October 29, 2019

RE: Headrick Garage and Pool Addition Watercourse Classification Memo - CAO19-014

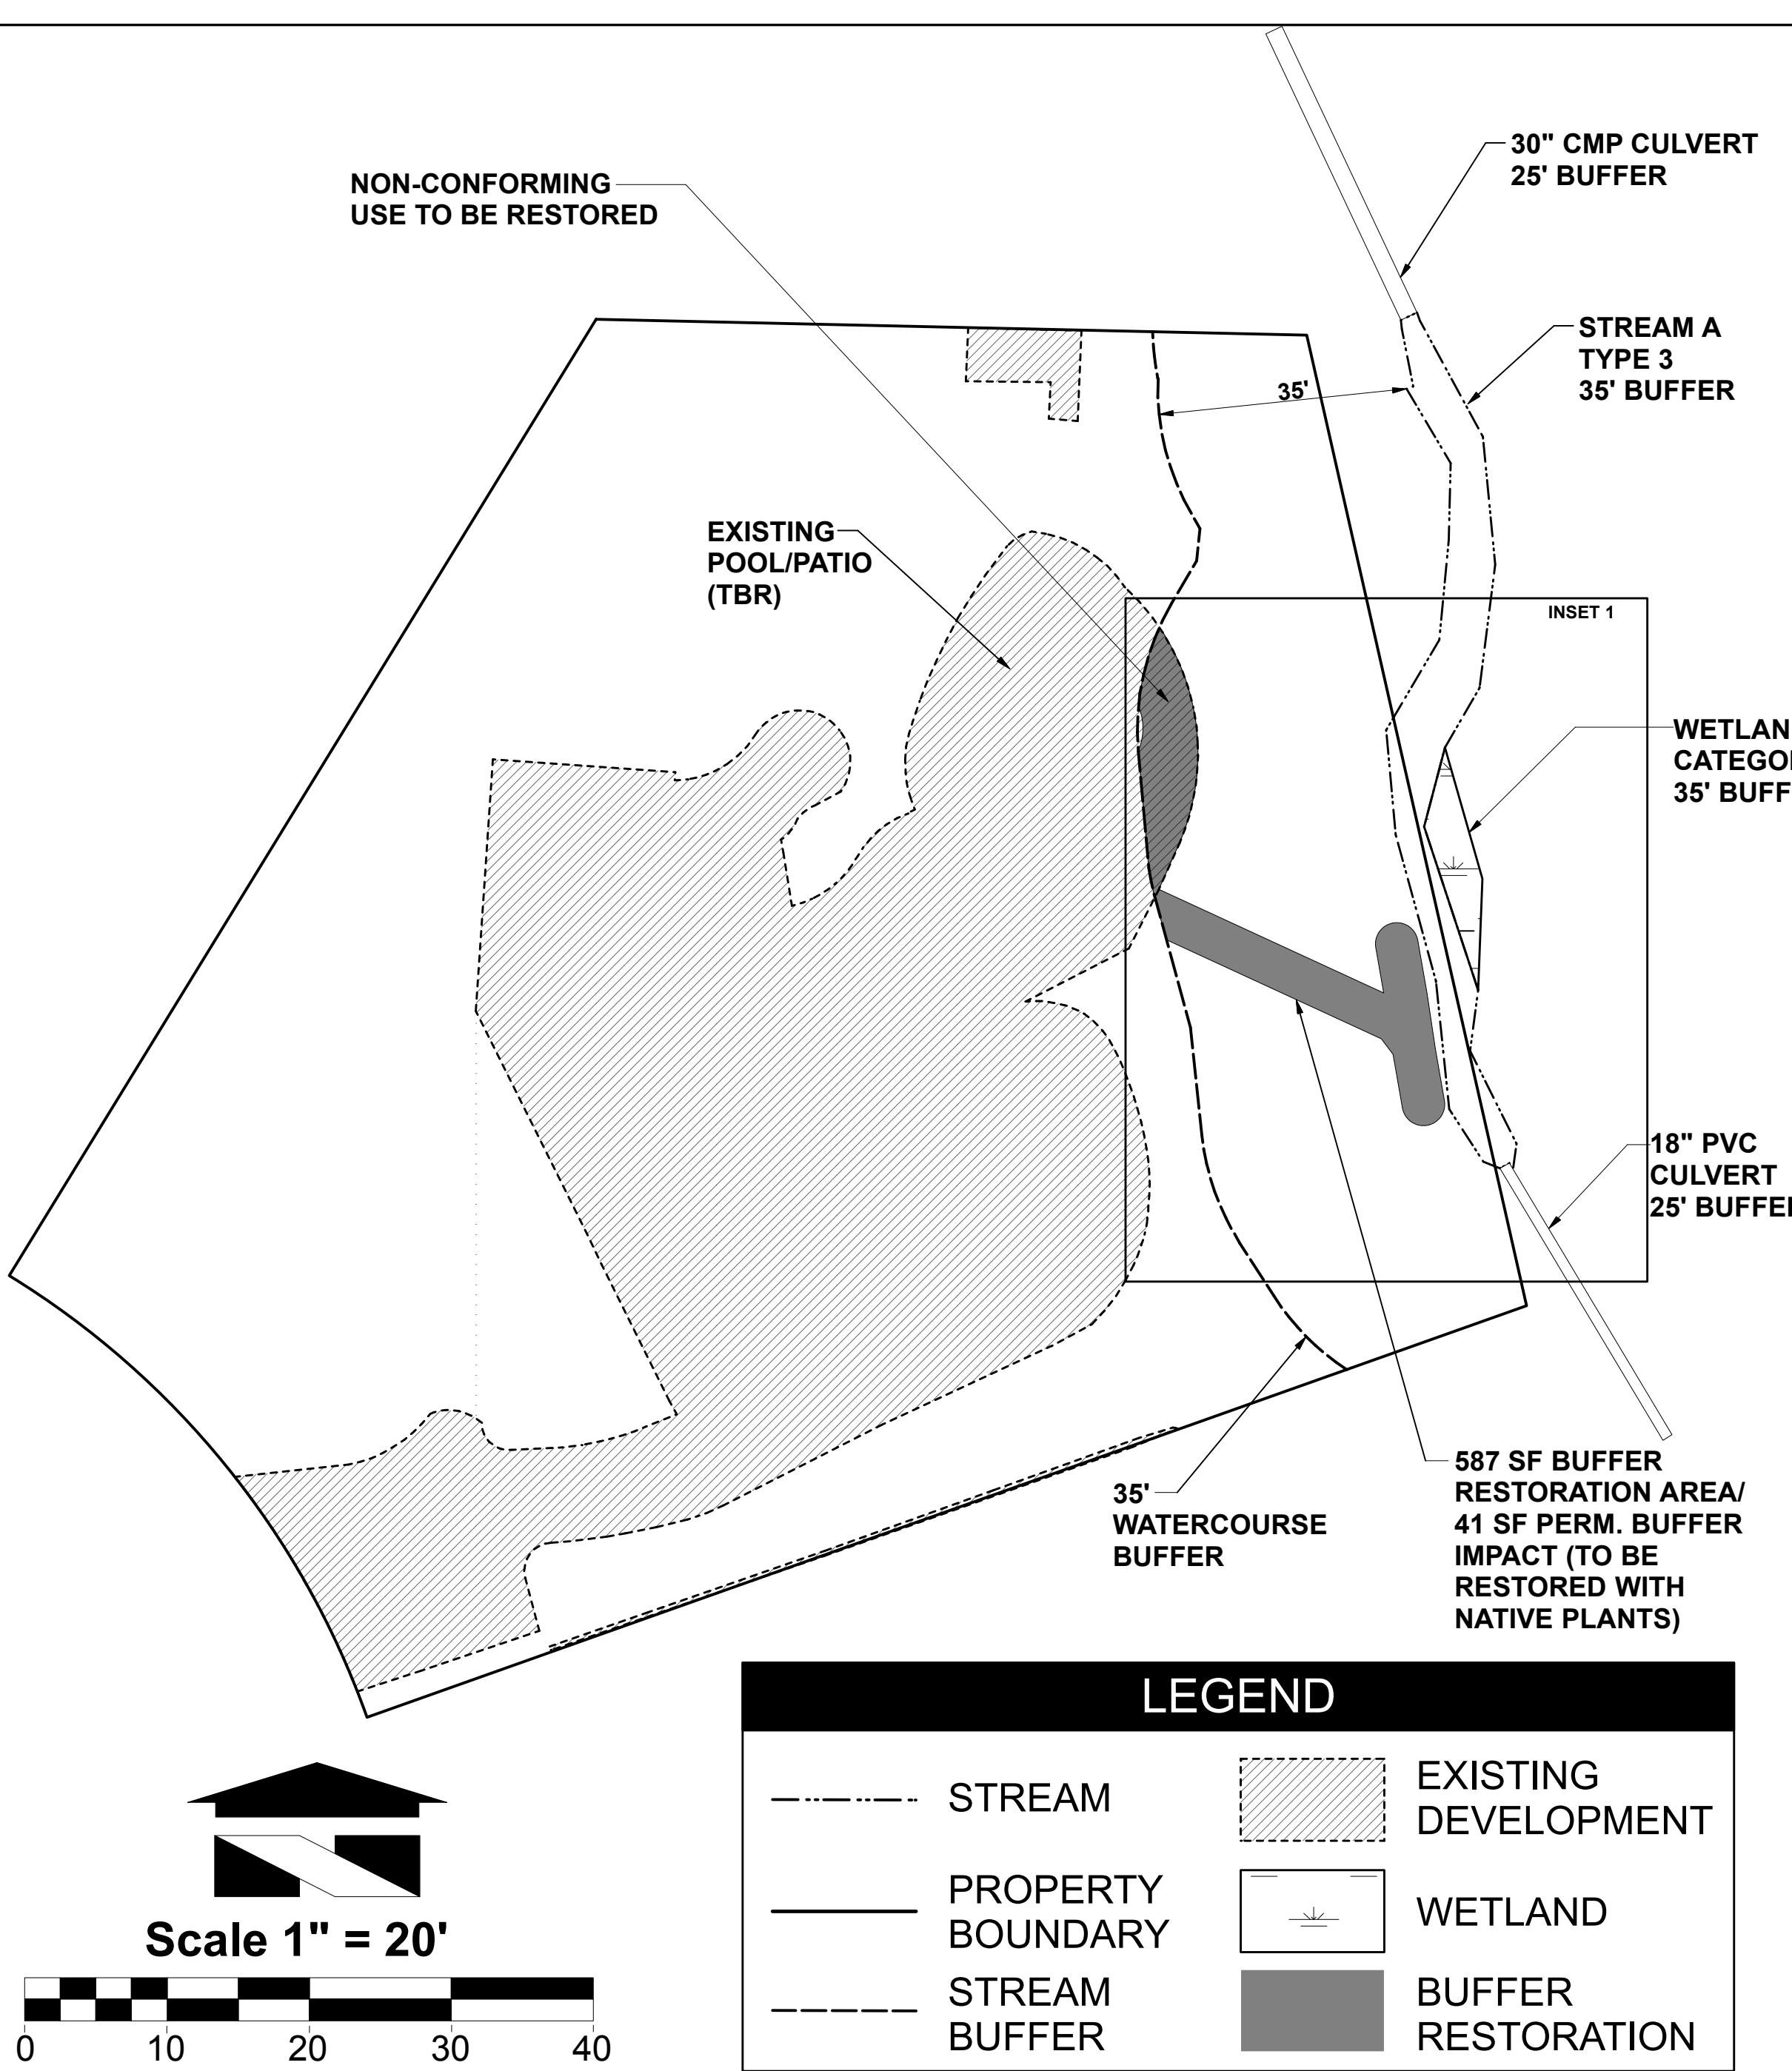
From a review of the site plan map showing the locations of the surveyed OHWM, it appears that the stream meets the criteria for bankfull width (i.e. >+2 feet). The streambed gradient is unknown at this time. More data is needed to establish the streams classification.

Applicant's response: The on-site portion of Stream A meets the criteria for bankfull width, but is upstream of a natural fish passage barrier according to the WAC (greater than 16 percent slope in with a contributing basin less than 50 acres), and an artificial fish passage barrier (culvert under E Mercer Way). See detailed discussion above. In the vicinity of the subject property, Stream A is correctly classified as a Type 3/Ns stream pursuant to the water typing rules of WAC 222-16-031, and pursuant to the rules in effect at the time of complete application for the current project. In the vicinity of the project, current and future development should not be subject to regulatory setbacks associated with fish-bearing streams based on the findings of this memo.
